Our reference: 19/00432/PINS

Your reference: EN070005

**Location: Southampton to London Pipeline Project**

**Proposal: Notification from Esso of acceptance of their DCO application (by the Planning Inspectorate) and deadline for registering as a Interested Party**

Illustration 3.42: Aerial photography of TC014 in Southwood Country Park SANG

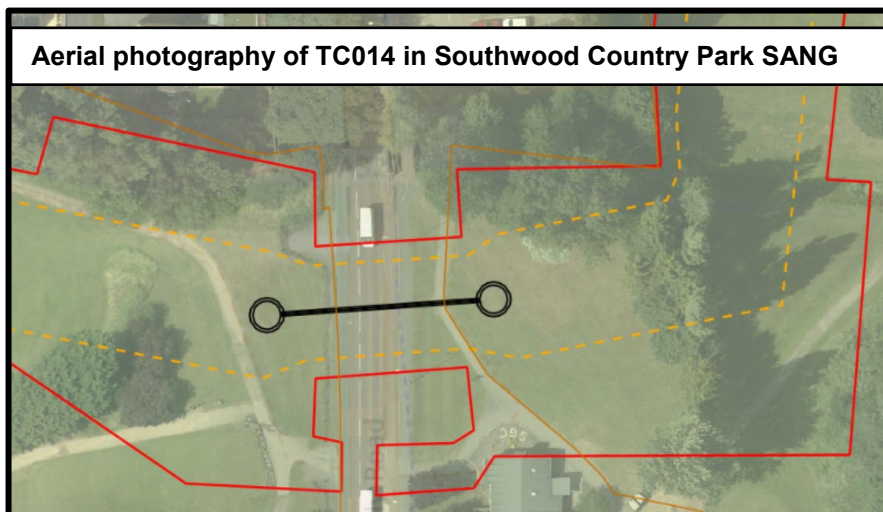
- 7.2.1 The EIA states that the Ively stream will be crossed using open trenching. This is likely to have a significant impact on the bank vegetation and river bed habitats. The route will also impact on the headwaters within the site, located adjacent to the stream. Rushmoor Borough Council is working with the Environment Agency on a strategic project to naturalise and enhance the Ively and Marrow streams and Cove Brook, and restore the headwaters and the floodplain throughout the site. This work is due to be undertaken in the summer of 2020. This project is funded by significant financial contributions from developers and funding from the EA. Rushmoor Borough Council is concerned that there will be a significant impact on the newly restored habitats as a result of this project. The Council would advocate a trenchless crossing to preserve the restored habitats and protect the headwaters from hydrological impact
